* Note that these comments are based on amended drawings which were not accepted by ADC due to the impending expiry date but that the Engineer was able to review)

Subject: RE: Planning Consultation on: P/84/21/DOC

Condition 6- surface water drainage design

Drawing Status	FOR APPROVAL						
Client	Future Group Development Ltd						
Project	Land at The Inglenook Pagham Road, Bognor Regis PO21 3QB						
Drawing Title	Proposed Drainage Arrangement Sheet 2 of 2						
Scale	1:200	Date	May 2021	Drawn By	DJL	Checked By	MJA
Drawing No.	D1966-103.2	Rev.	-

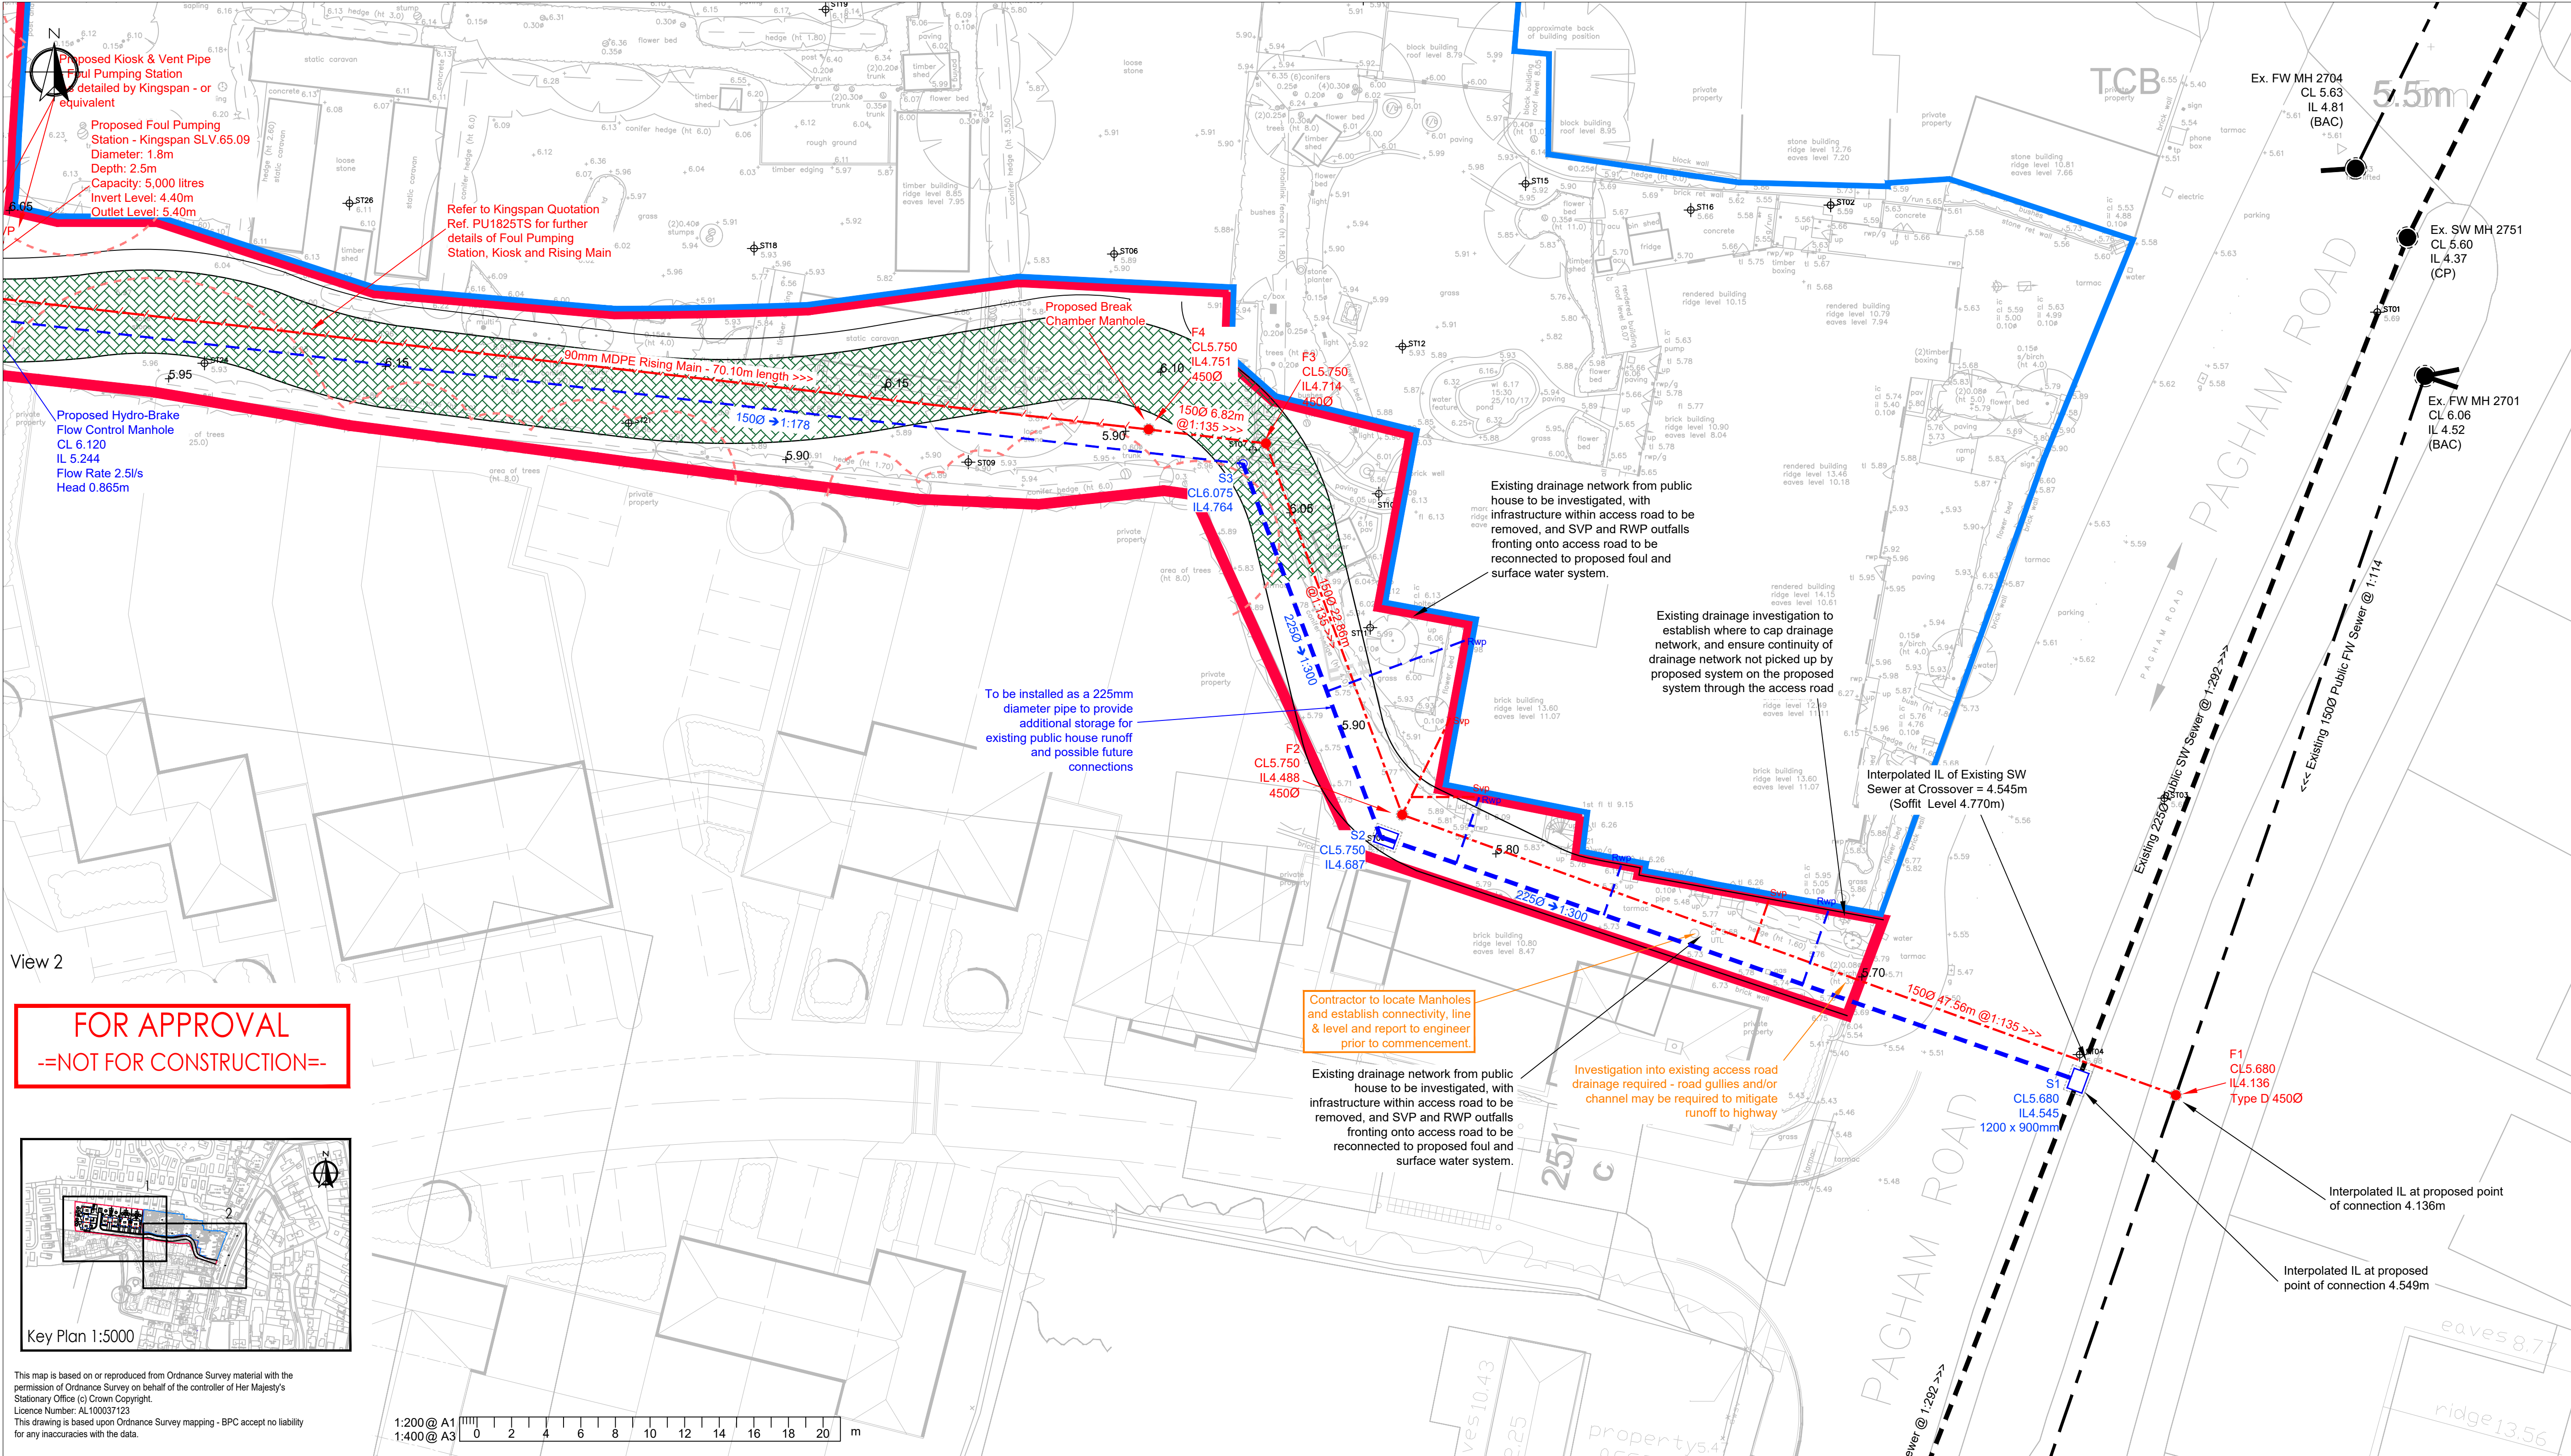
4. Please detail formation level of permeable paving on plans.

Please see revised drawing. These are detailed accordingly. *Formation levels and diffuser inverts appear to be at odds. Some diffuser inverts appear to be below formation level of pp. Please either revise or add further formation levels to make this clear.*

FLOW CONTROL CHAMBER
(Scale 1:20)

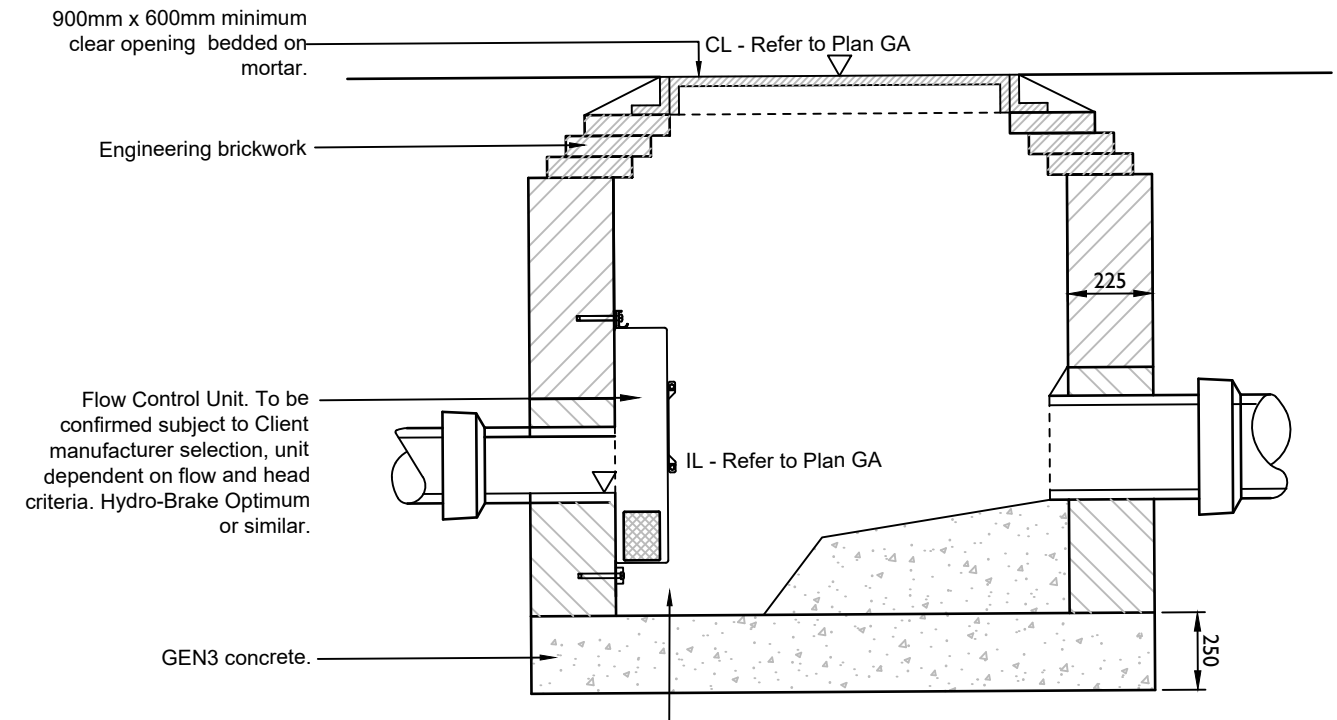
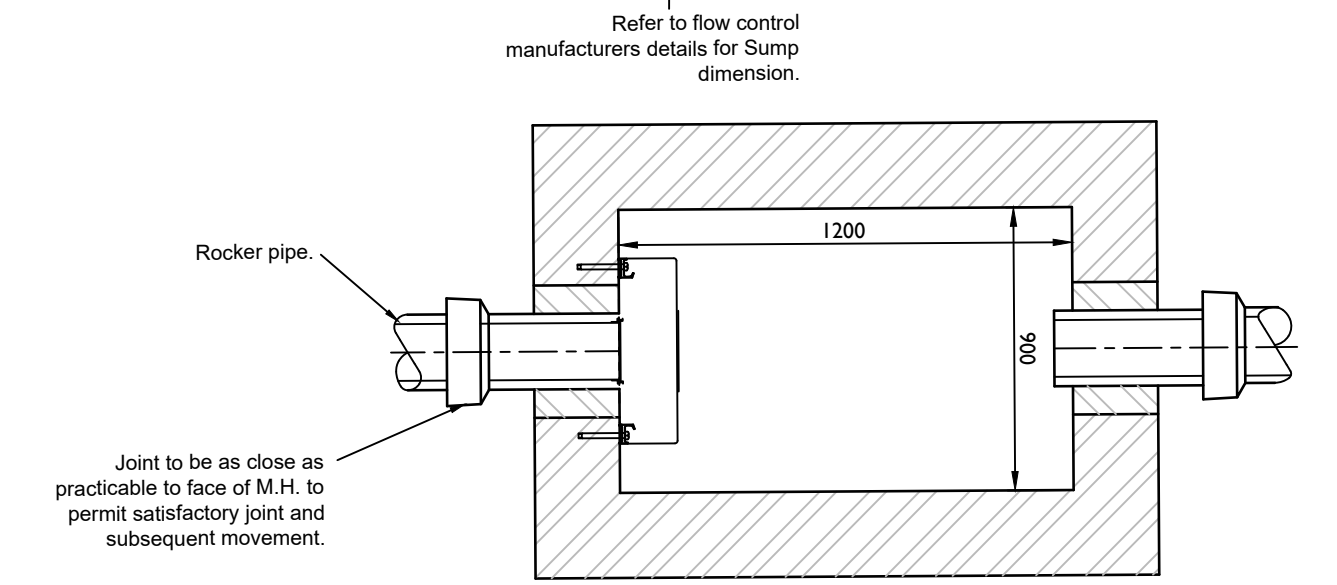
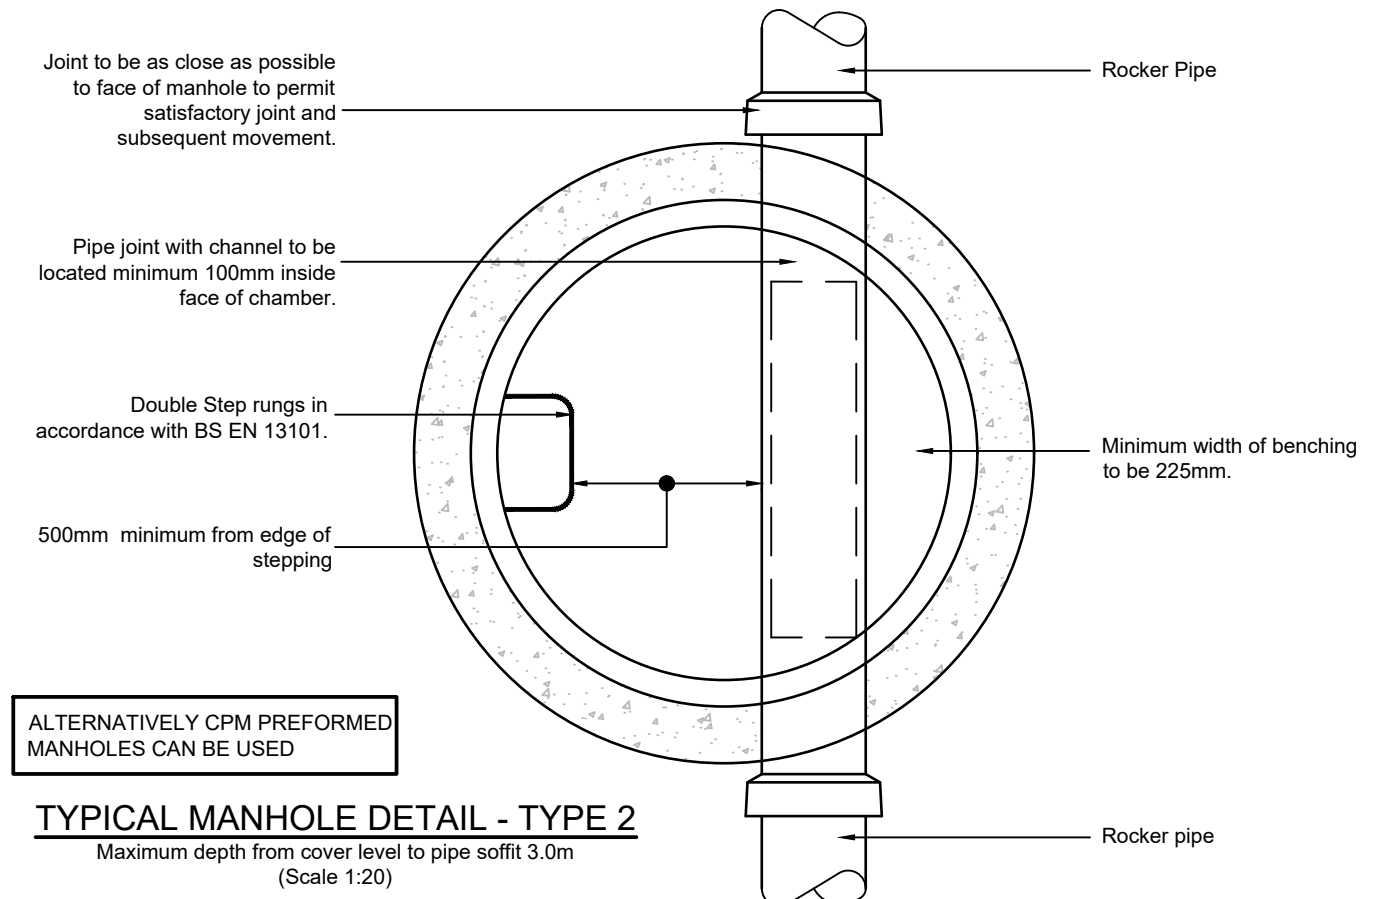
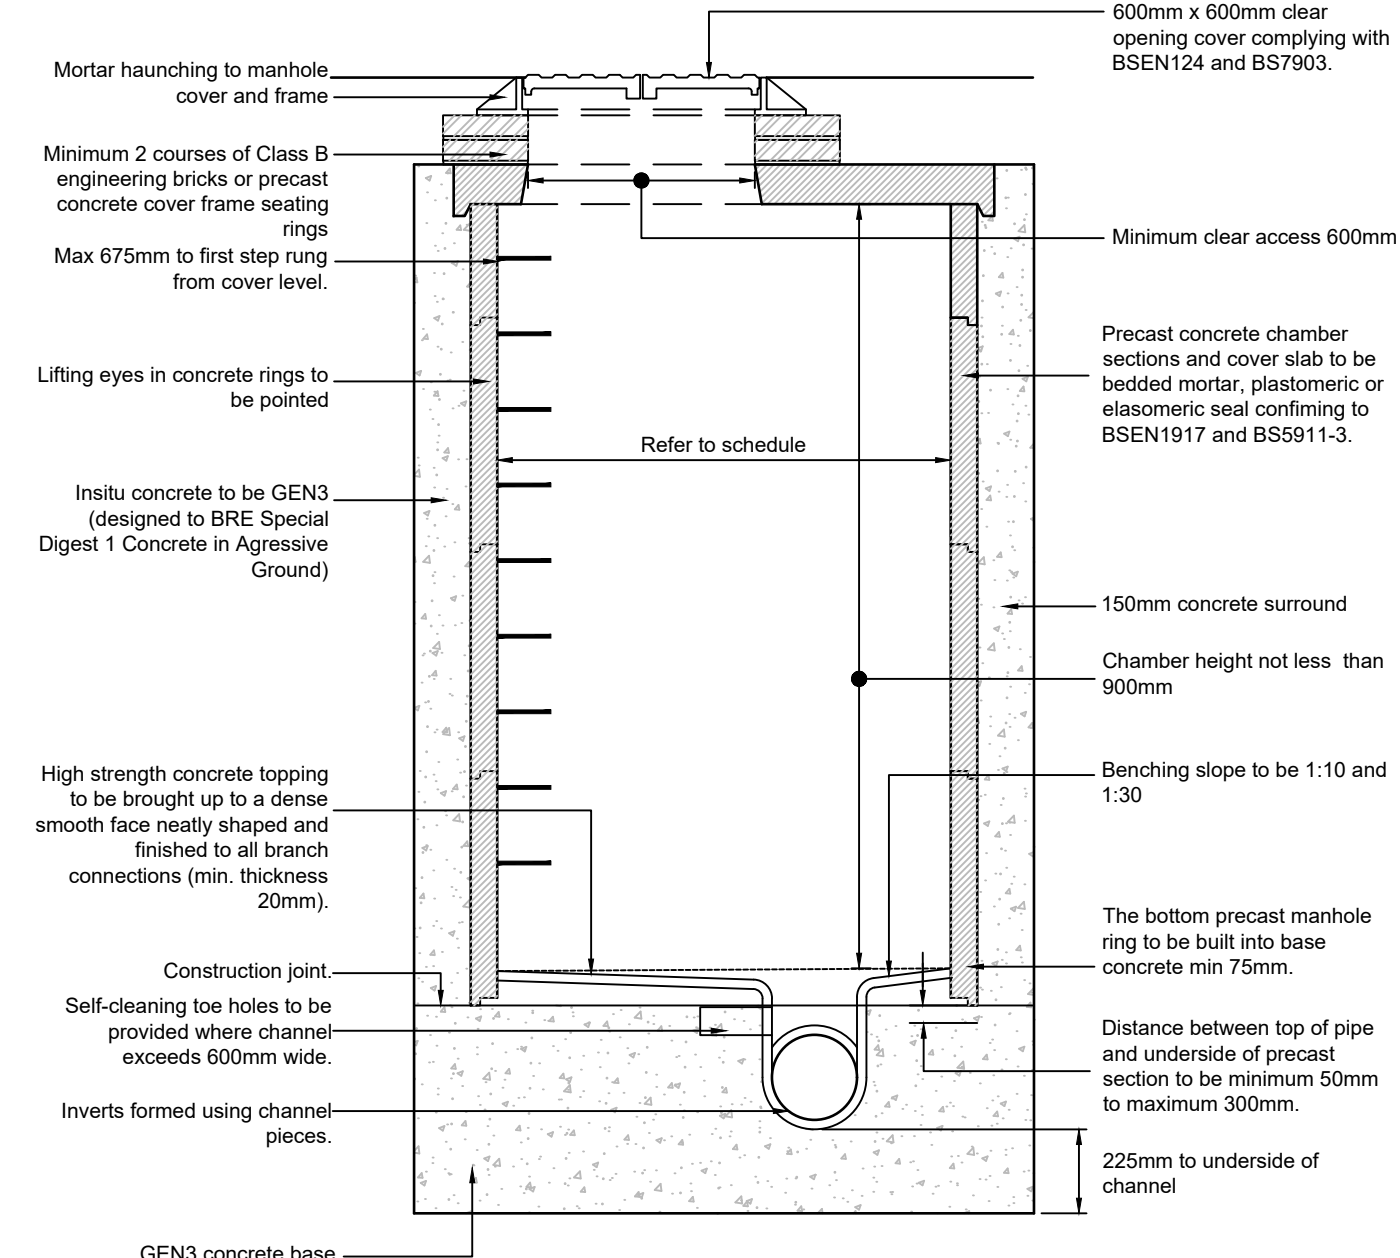
5. Please state hydrobrake reference on both layout and construction detail.

Please see revised drawings. *Reference number not included on layout or detail.*

6. Please show hydrobrake bypass door, operating rope and fixing and construction detail.

Please see detail, with unit specified. Not required for shallow chambers, in accordance with manufacturer's recommendations. Invert is <1.0m from cover level – can be accessed by hand from ground level for clearance & emergency maintenance. *I cannot understand how safe operation will be possible in times of blockage without a bypass door. A bypass door should be provided.*
